Application Reference: 2025/0088

Location: 52 Garden House Close, Monk Bretton, Barnsley, S71 2ED.

This application seeks planning permission for the erection of a two-storey extension to the side and the installation of a dormer window to the rear.

Drawing Title
PROPOSED ELEVATIONS

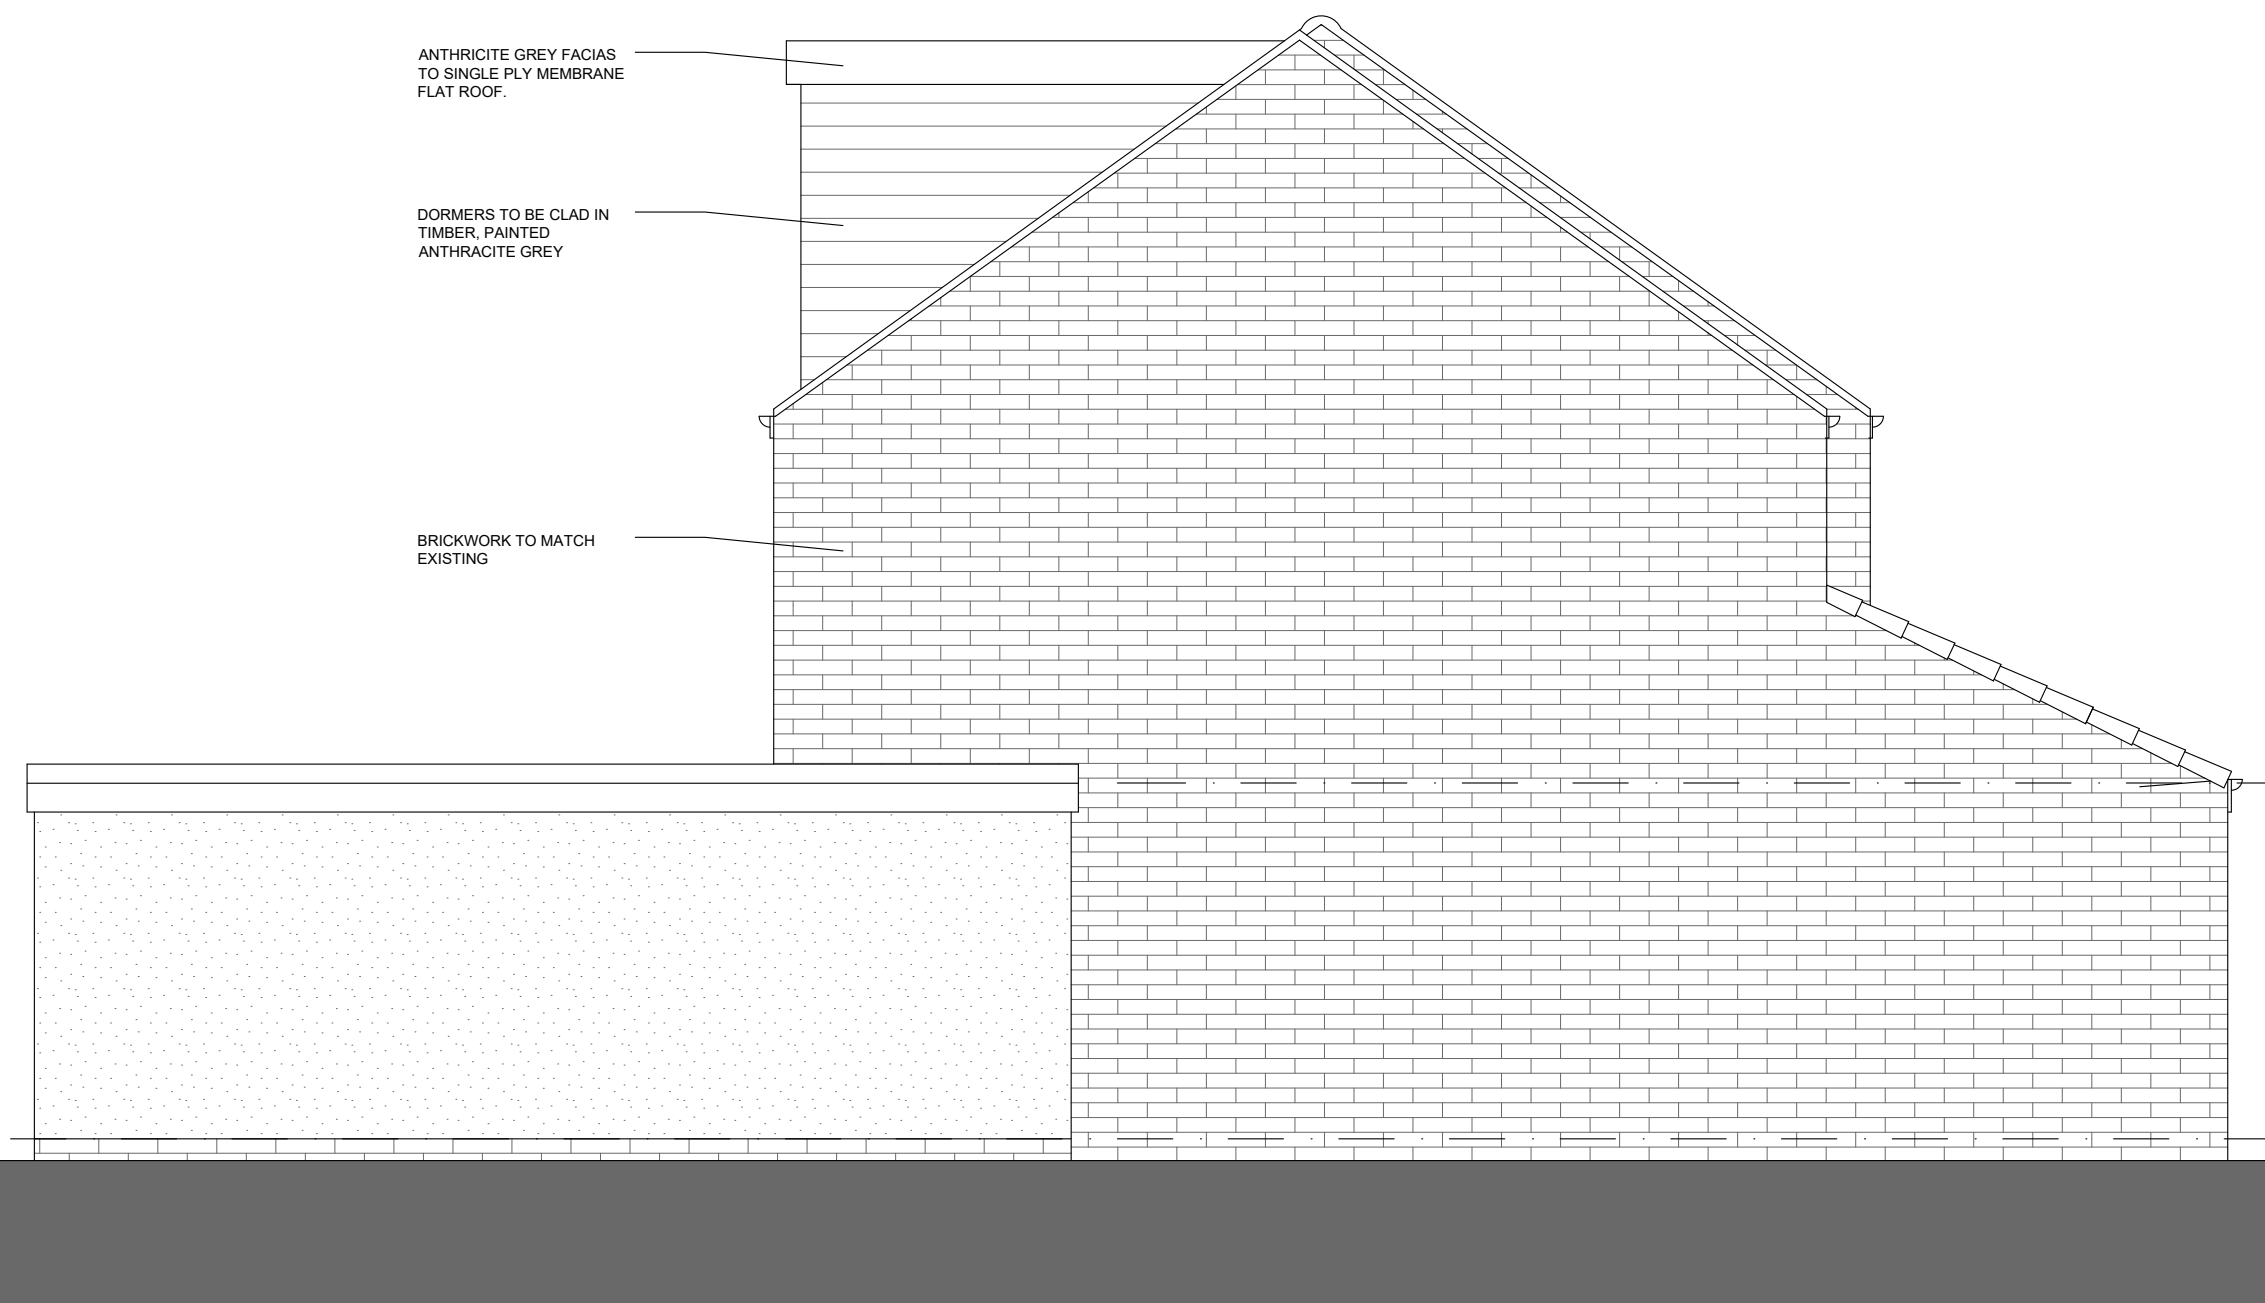
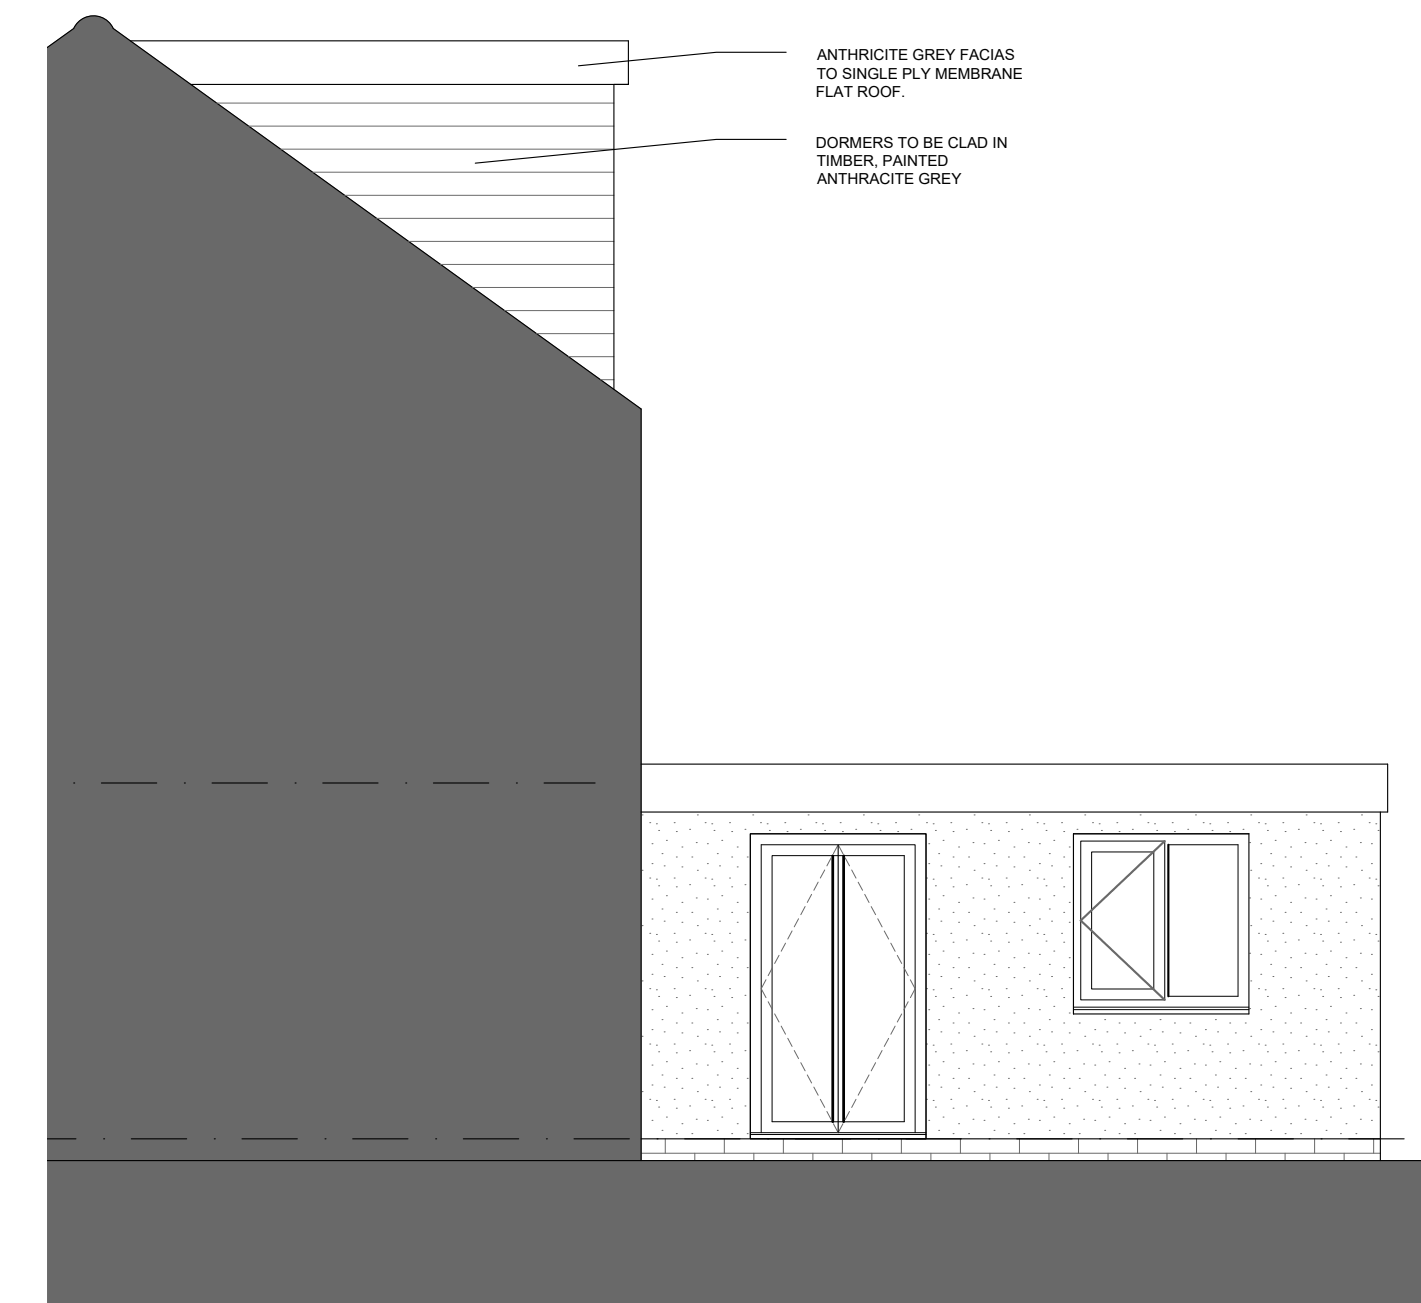
The House extensions and other domestic alterations SPD establishes specific design guidance for proposals for dormer windows. It states that the design should reflect the character of the area, the surrounding buildings and the age and appearance of the existing building, and to determine whether a dormer window on the front or principal elevation would be appropriate, the roofs of the surrounding buildings should be examined. Unless the street scene is characterised by dormers on the frontage, or these are a feature of the surrounding area/street/terrace, dormer windows should be located on the rear or secondary elevations. Dormer windows should be set within the roof plane and not built off external walls. Dormer windows should also be set below the ridge, set back from the eaves and set away from party walls with adjacent properties.

In this instance, the proposed dormer window would be installed to the rear, and whilst it would adopt a relatively large scale, the dormer window would be set back from the original eaves and set below the original ridge. The proposed dormer window would be painted anthracite grey to sympathetically reflect the colour of existing roofing materials. The dormer window would be visible from Lamb Lane, but it would not appear as an overtly dominant or prominent feature within the street scene that could otherwise detract from its character and new apertures would align with existing apertures.

The House extensions and other domestic alterations SPD establishes specific design guidance for proposals for two-storey side extensions. It states all two-storey side extensions should adopt a roof

following the form of the existing roof with a set back from the front elevation and set down from the existing ridge line. The sideways projection should not exceed more than two thirds the width of the original dwelling.

In this instance, the proposed extension would be set back from the front elevation at first floor level and would not adopt an excessive sideways projection more than two thirds the width of the original dwelling. The proposed extension be set below the existing ridge line, would adopt a pitch roof and would be constructed of closely matching external materials. The extension would therefore appear subservient and would be a sympathetic addition, designed in accordance with the Council's design guidance.

During the application process, the proposal was amended to set the extension down and back, alter the materials of the dormer window, remove a second dormer and align openings.
